NSW RURAL FIRE SERVICE

Your reference: SSD 8660
Our reference: D17/2639
DA19013117187 RB

Proposed development for Kariong Sand and Soil Supplies Facility at 90 Gindurra Road Somersby

The New South Wales Rural Fire Service (NSW RFS) provides the following advice regarding bush fire protection measures for the proposed development:

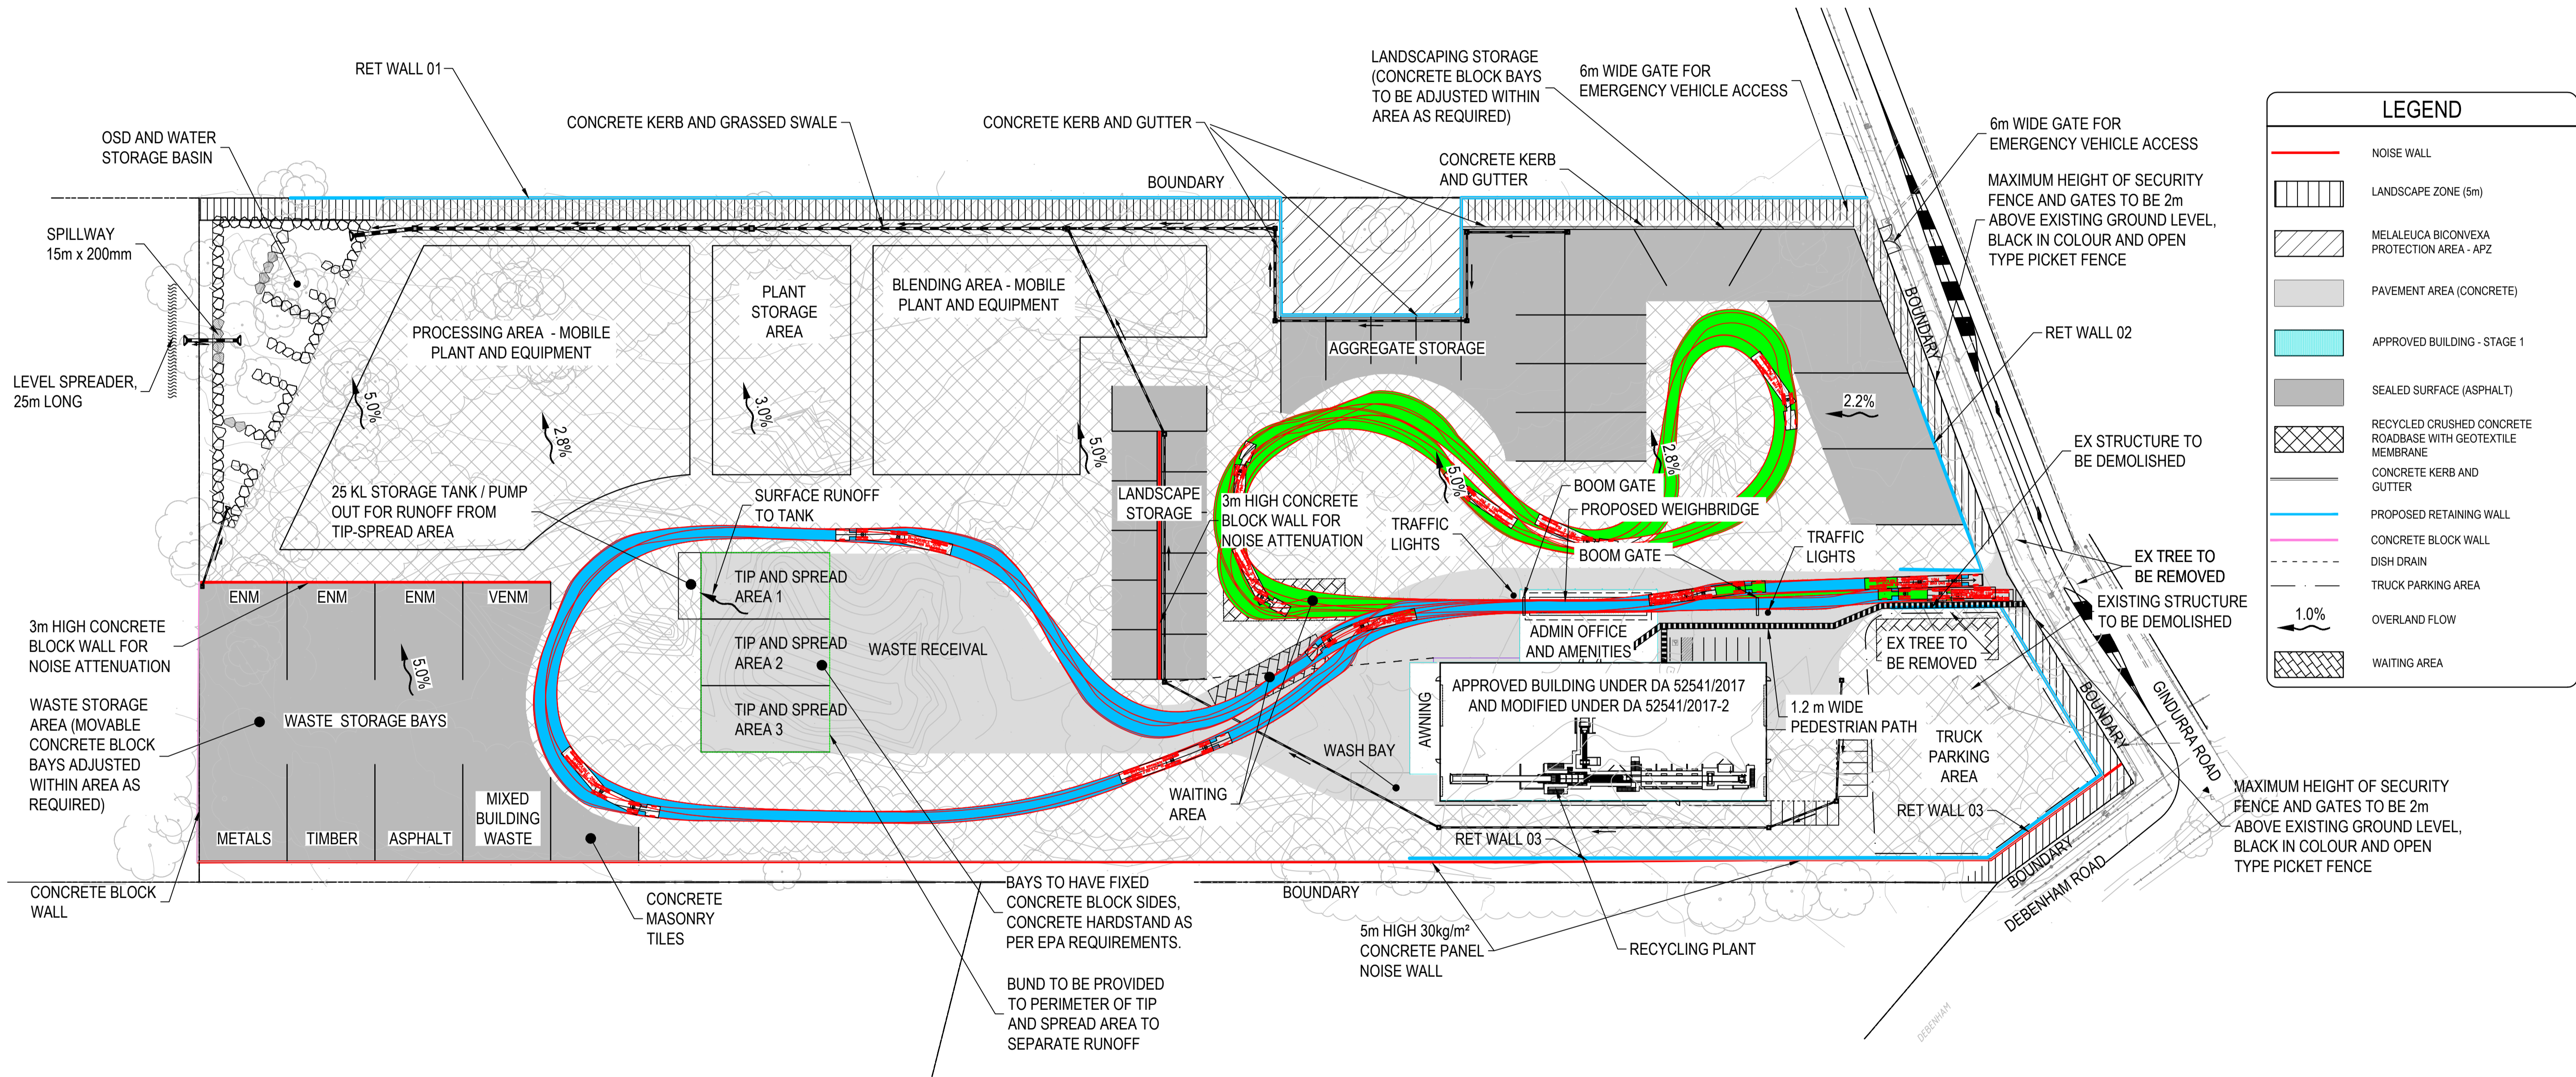
1. At the commencement of building works and in perpetuity, the entire development area of the subject site, as shown on the 'Concept General Arrangement Plan' prepared by Cardno Pty Ltd dated 27/04/2018 (drawing number 80518002-CI-106, Revision 13), shall be maintained as an inner protection area (IPA) as outlined within section 4.1.3 and Appendix 5 of *Planning for Bush Fire Protection 2006* and the NSW Rural Fire Service's document *Standards for asset protection zones*.
